Neil McBride
Head of Planning
Planning Services
Lincolnshire County Council
County Offices
Newland
Lincoln LN1 1YL
Tel: [REDACTED]
E-Mail: [REDACTED]@lincolnshire.gov.uk

Date: 7 December 2023

PLANNING ACT 2008 – SECTION 89 AND THE INFRASTRUCTURE PLANNING (EXAMINATION PROCEDURE RULES) 2010 – RULE 8 APPLICATION BY WEST BURTON SOLAR PROJECT FOR A DEVELOPMENT CONSENT ORDER

Figure 6.1 Abnormal Load Movements

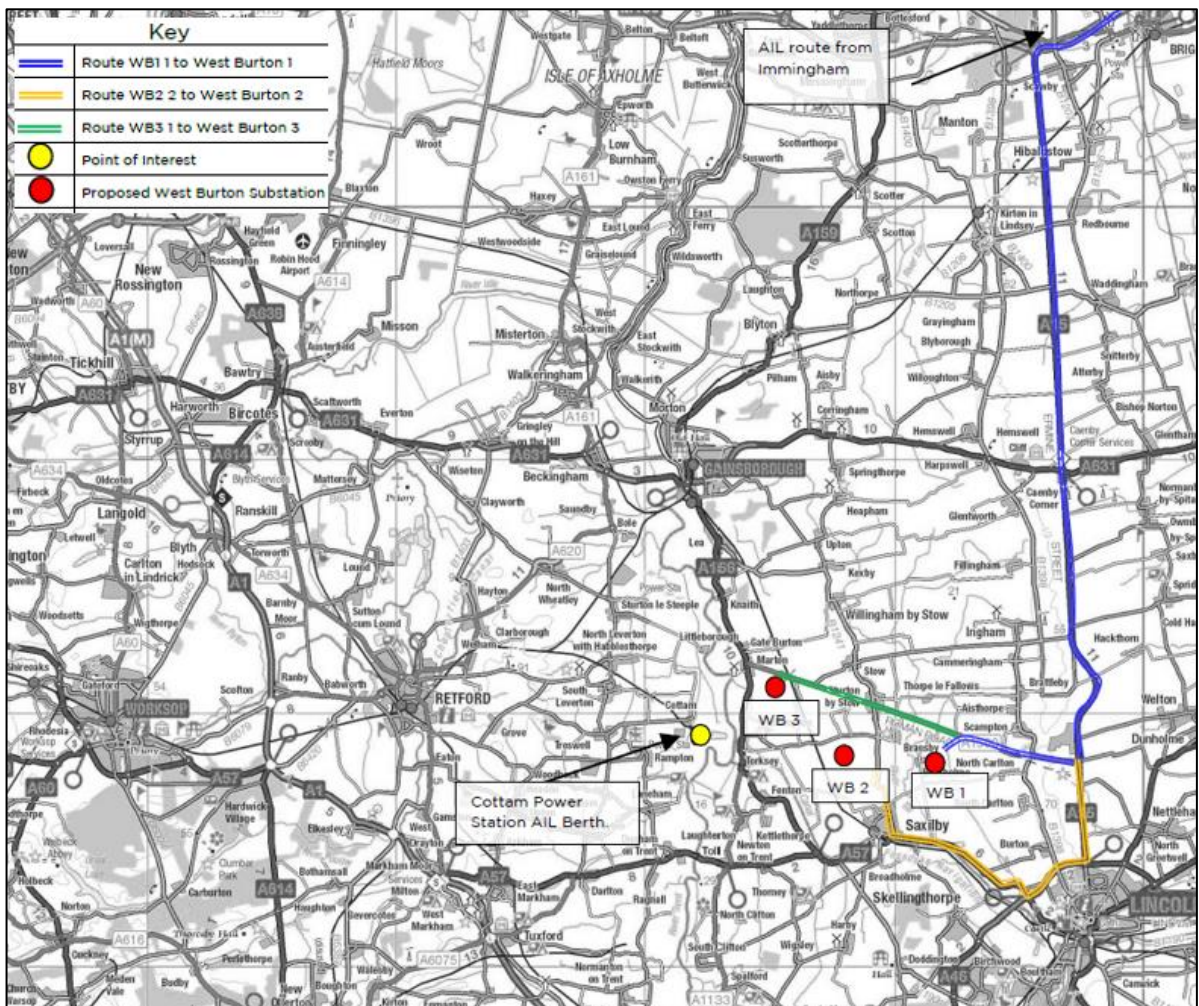
- At this stage a highways objection is raised to the use of the highway to gain access to the construction access point for West Burton 1. It is not considered that this highway is suitable for abnormal loads of 100 tonnes and 36m in length. The road is a rural lane which is not constructed for these loads and the width and alignment would prohibit such a large vehicle using this route. For this reason there is significant issues with highway safety and therefore contrary to Local Plan Policy S47.
- That if the Secretary of State grants the Development Consent Order a comprehensive and appropriate package of Community Benefits is secured and delivered to compensate for the identified negative impacts that the proposed development would cause to the communities affected by this project.
